16 May 2018

Our Reference: SYD17/00415/05 (A22273450)  
Department's Ref: SSD 8707

**NOTICE OF EXHIBITION – CONCEPT DEVELOPMENT APPLICATION FOR IVANHOE ESTATE REDEVELOPMENT IN IVANHOE PLACE, MACQUARIE PARK**

Figure 17: Proposed MPBPCI Stage 1 Works

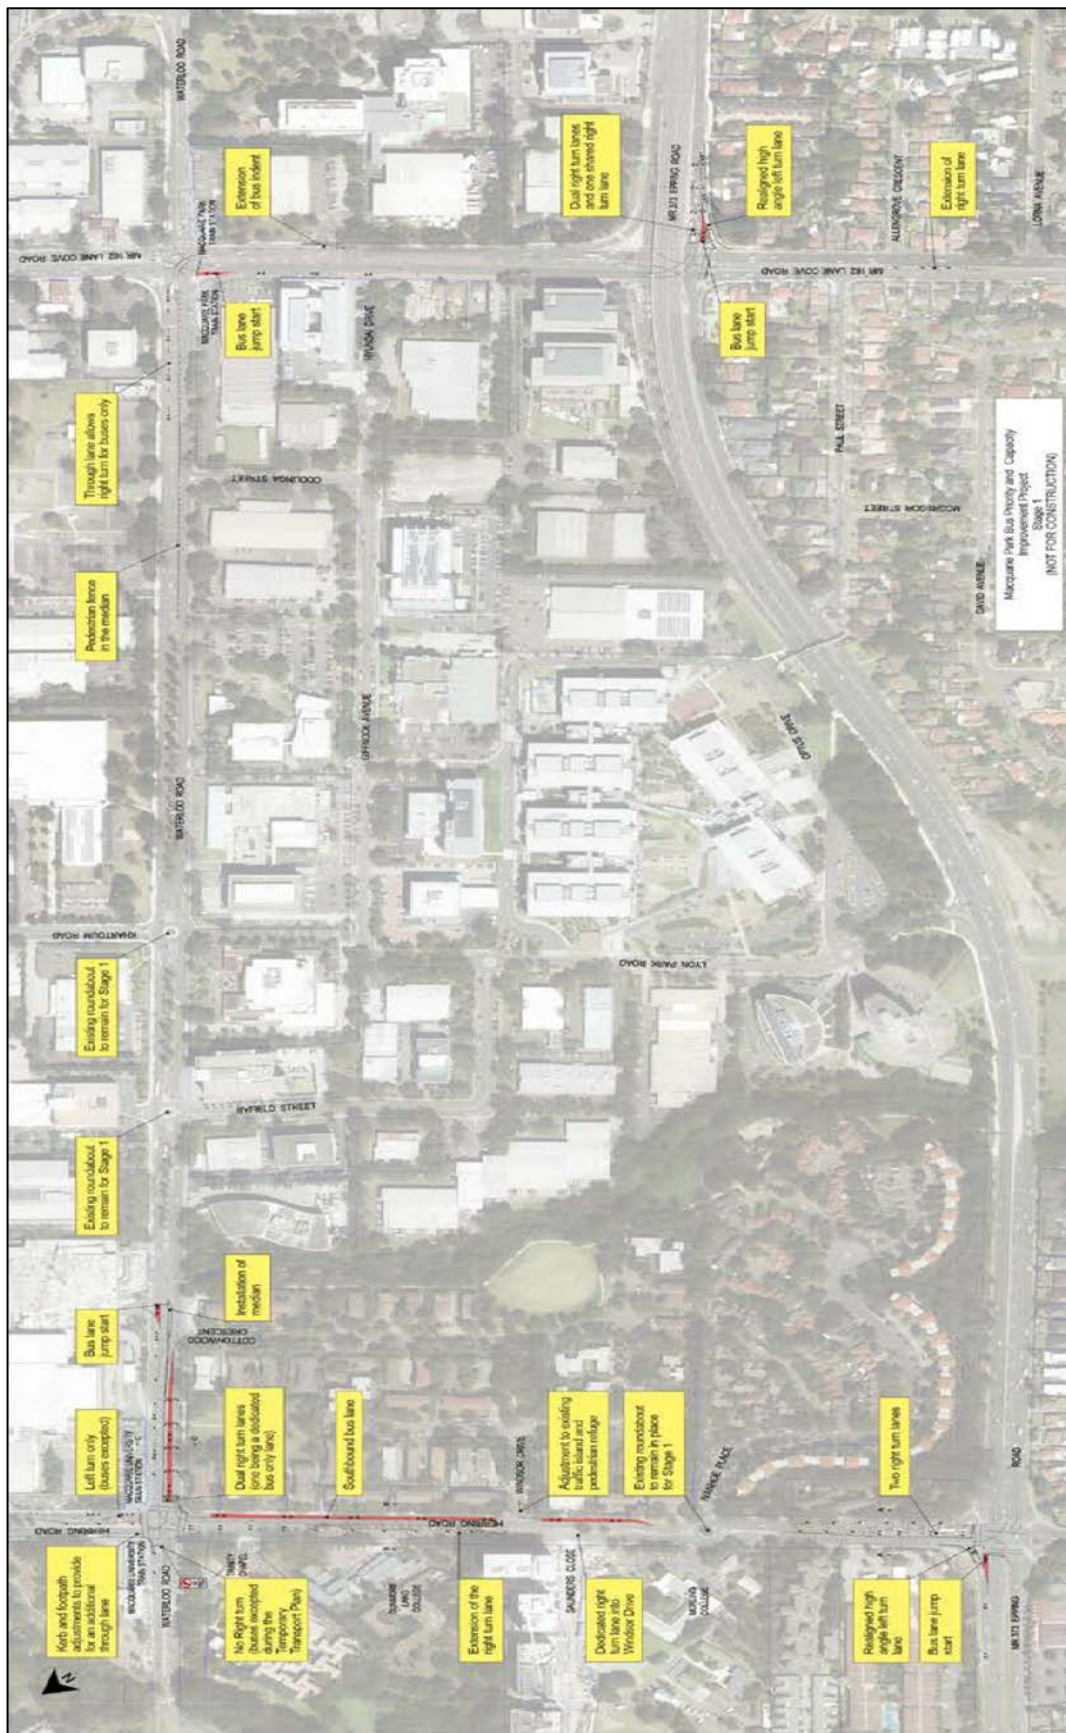
The subject property is affected by a road proposal for the Macquarie Park Bus Priority Stage 1 project as shown by red colour on the attached Aerial – "X". All new building or structures together with any improvements integral to the future use of the site are to be erected clear of the land required for the road and wholly within the freehold property (unlimited in height or depth) along Herring Road and Epping Road boundaries.

Figure 31: Proposed changes at the intersection of Herring Road and Ivanhoe Place

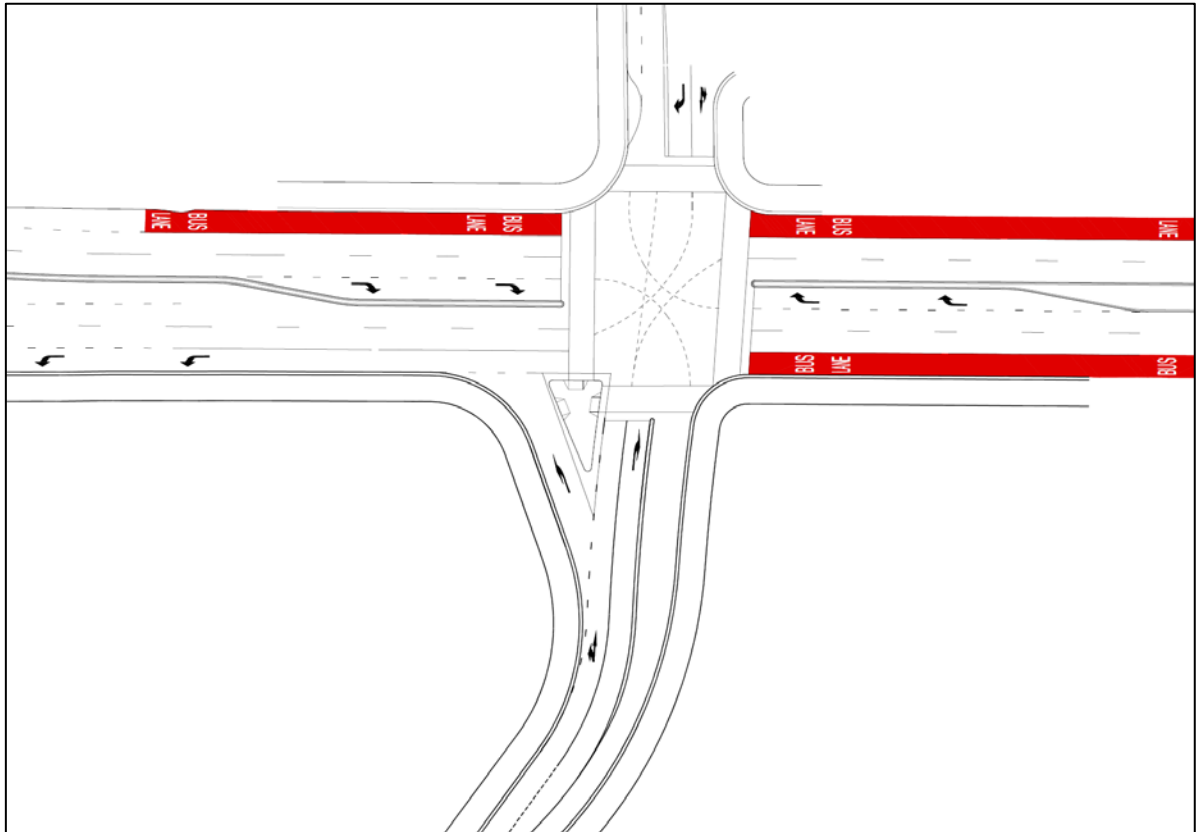
As per the submitted Transport Management and Accessibility Plan (TMAP) a 'U-turn' facility is to be provided as part of Stage-1 development. If the existing roundabout at Herring Road/Ivanhoe Place would be required to be replaced with traffic signals prior to completion of Stage-1 development, it will be necessary to construct the 'U-turn' facility in Ivanhoe Place prior to the commencement of Stage-1 construction works. Roads and Maritime will provide the developer advice on when the 'U-turn' facility should be completed.
